**WRITTEN SUBMISSIONS OF NFU REGARDING THE A303 AMESBURY TO BERWICK DOWN
SCHEME DEVELOPMENT CONSENT ORDER 201 [...]**

PLANNING INSPECTORATE REFERENCE NO TR010025

**SUBMISSIONS OF NATIONAL FARMERS UNION ON THE SPECIFIC HEARING 6 TRAFFIC AND
TRANSPORTATION ON 13TH JUNE 2019**

DATE 21ST JUNE 2019

Drawing file: TR010025 / TR010025-001755-Figure 13.3A and B Proposed Public Rights of Way Revision 3.pdf

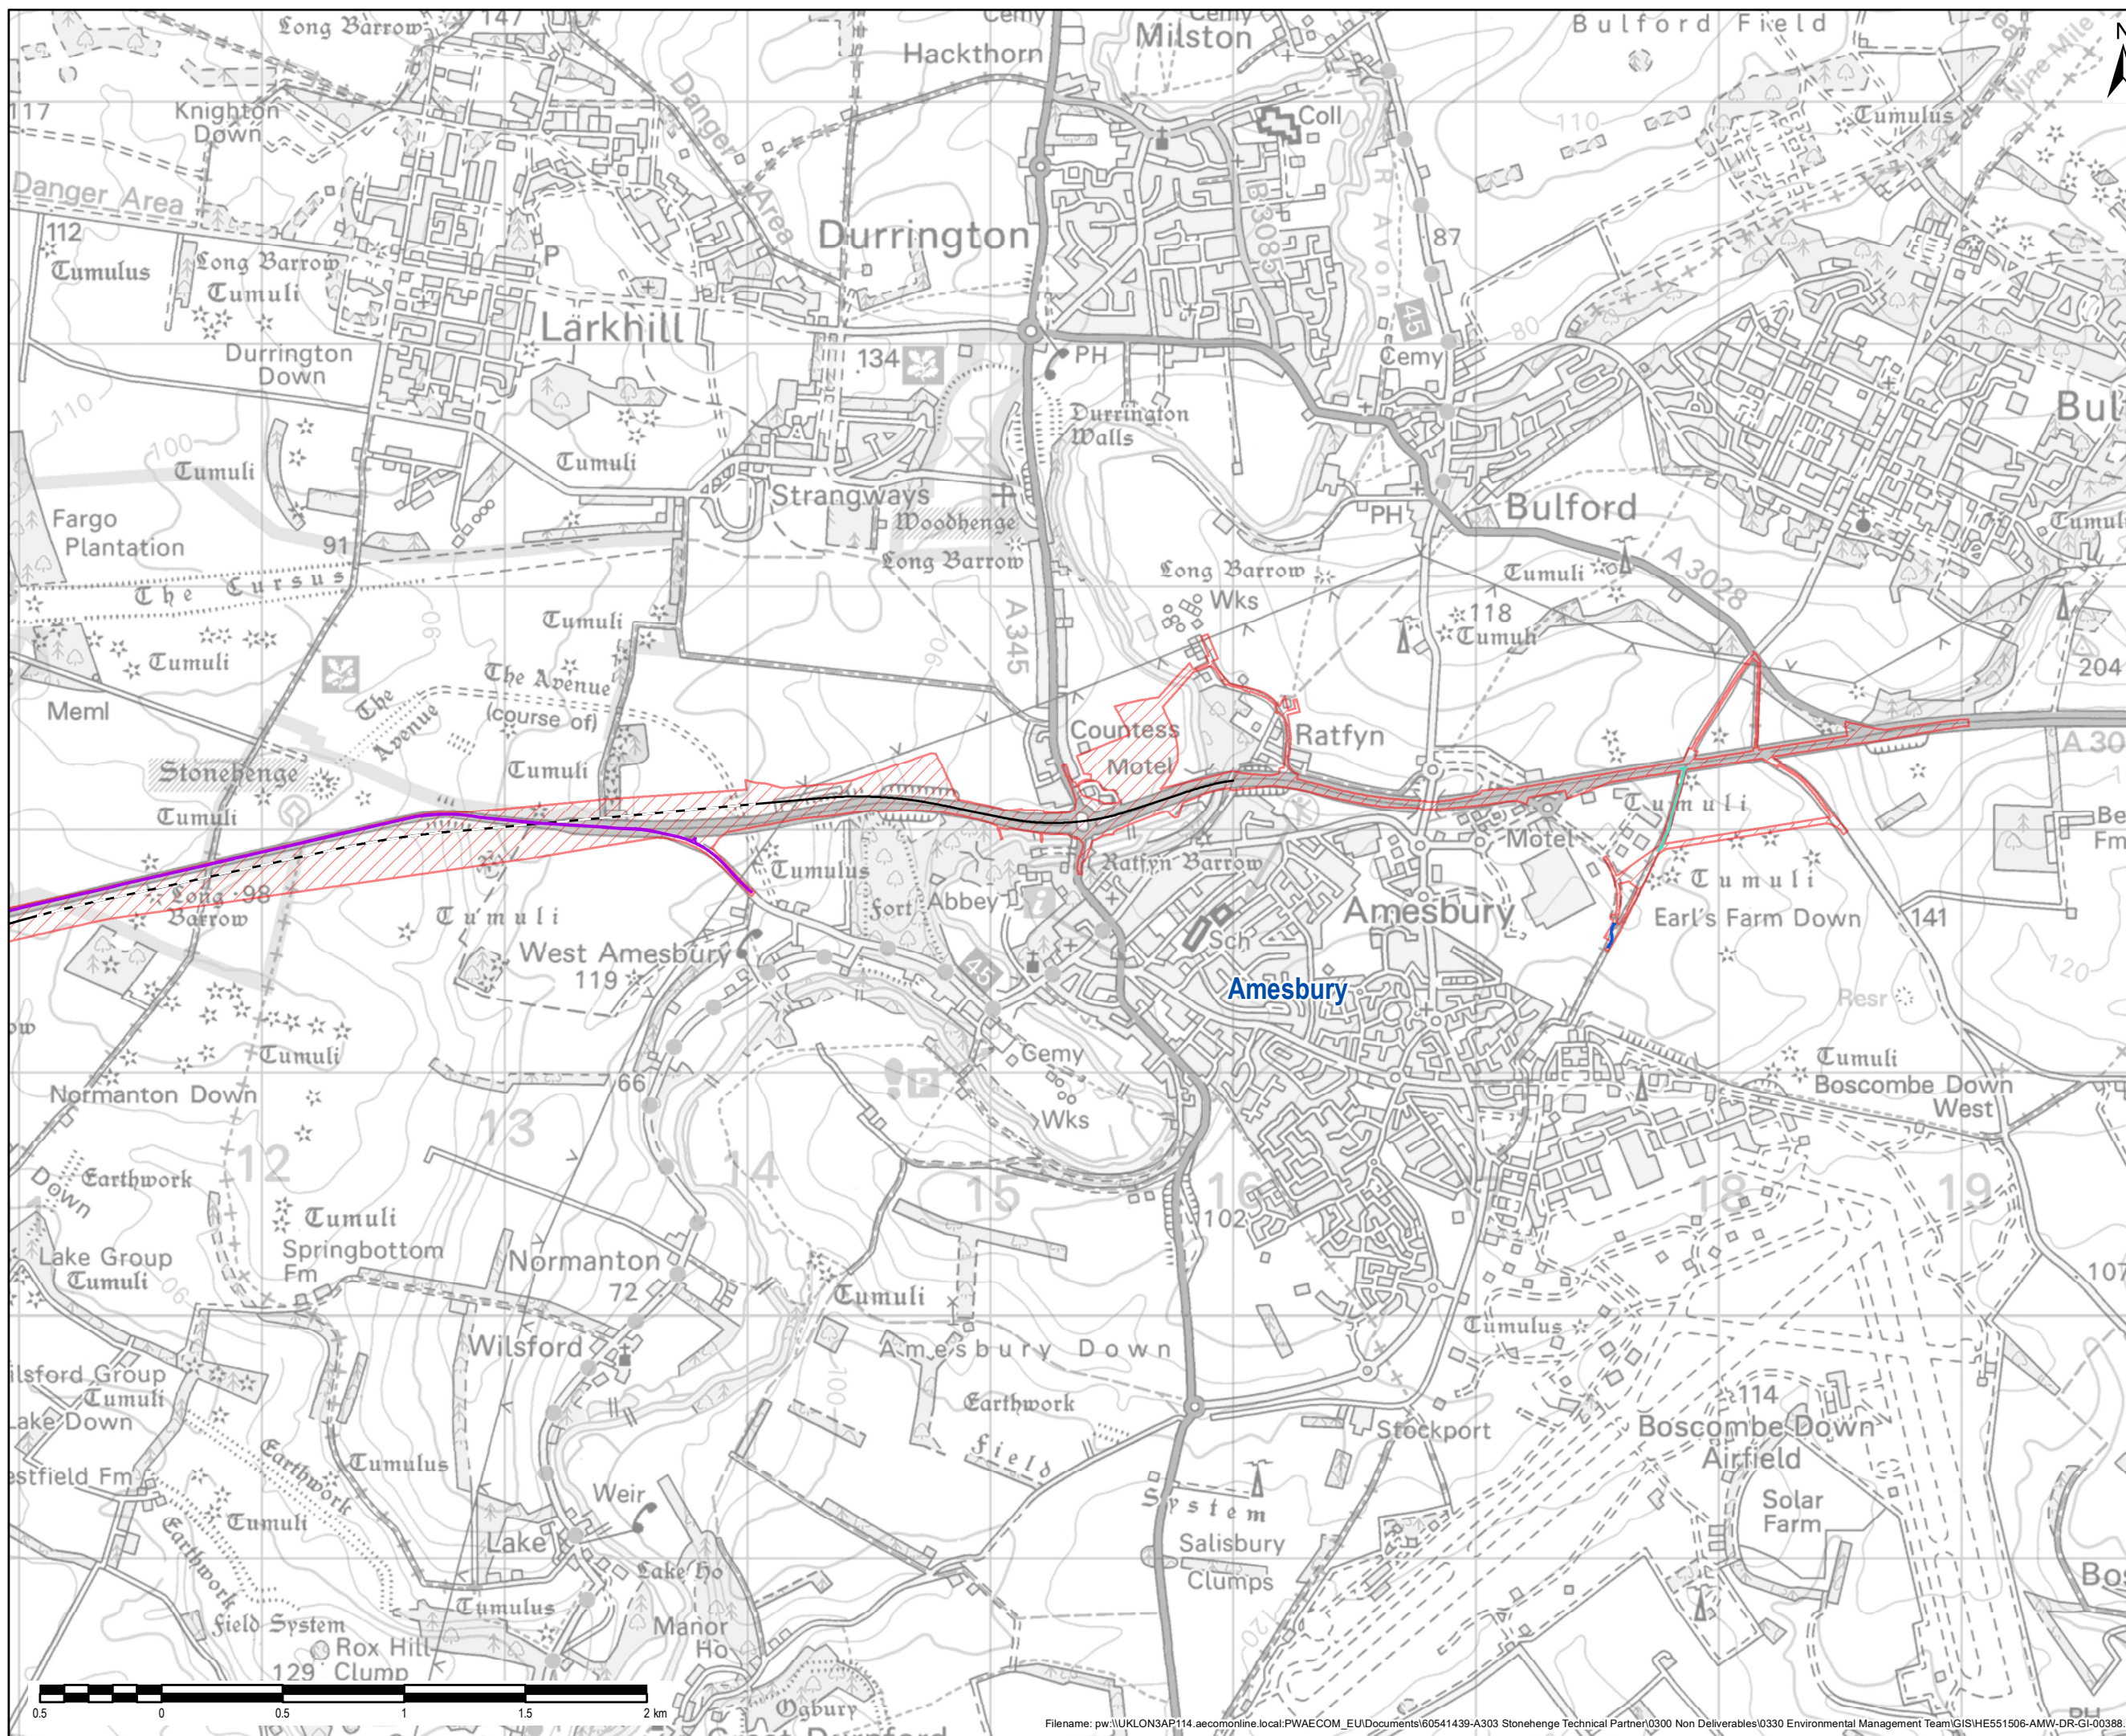
- A new restricted byway on the west side of Green Bridge 1 on the north and south side of the A303.
- A new bridleway to the west side of Longbarrow Junction from Winterbourne Stoke.
- A new bridleway going round the new Longbarrow junction and continuation to Green Bridge 4.
-

These are new rights of way and should not be created as they are all taking further land out of agricultural production and they are not needed for the highway scheme itself. The Planning Act 2008 is very clear that no more land should be taken than is need for the scheme itself.

2.2 **SLAN 3** junction at Yarnbury Castle should be improved to be an even safer crossing. If this improvement is carried out it is not necessary to create the new restricted byway north or south of the A303.

2.3 The proposed **new bridleway** from Winterbourne Stoke to Longbarrow junction should not be created. HE confirmed at the hearing that this new bridleway does not connect up to a bridleway in Winterbourne Stoke.

2.4 If it can be proven that a **new cycle way** is necessary in to Winterbourne Stoke then this should be created along the existing A303 which will be maintained as a local access route. It is not necessary to take agricultural land out of production to create a cycle way.

2.5 **Green Bridge 4** should not be created as a cut and cover tunnel 150m wide. It is strongly felt that this Green Bridge should stay in line with the A360. It was highlighted at the hearing that a right of way should stay with the alignment and be direct and easy to use.

2.6 Omission of a link between **AMES 11 and AMES 12**. The NFU stated that if a decision was made by the Examiners that a link should be kept between AMES 11 and AMES 12 for the Trail Riders then it should be provided along the existing A303 with agricultural access only. No land should be taken out of agricultural production to create a new link.
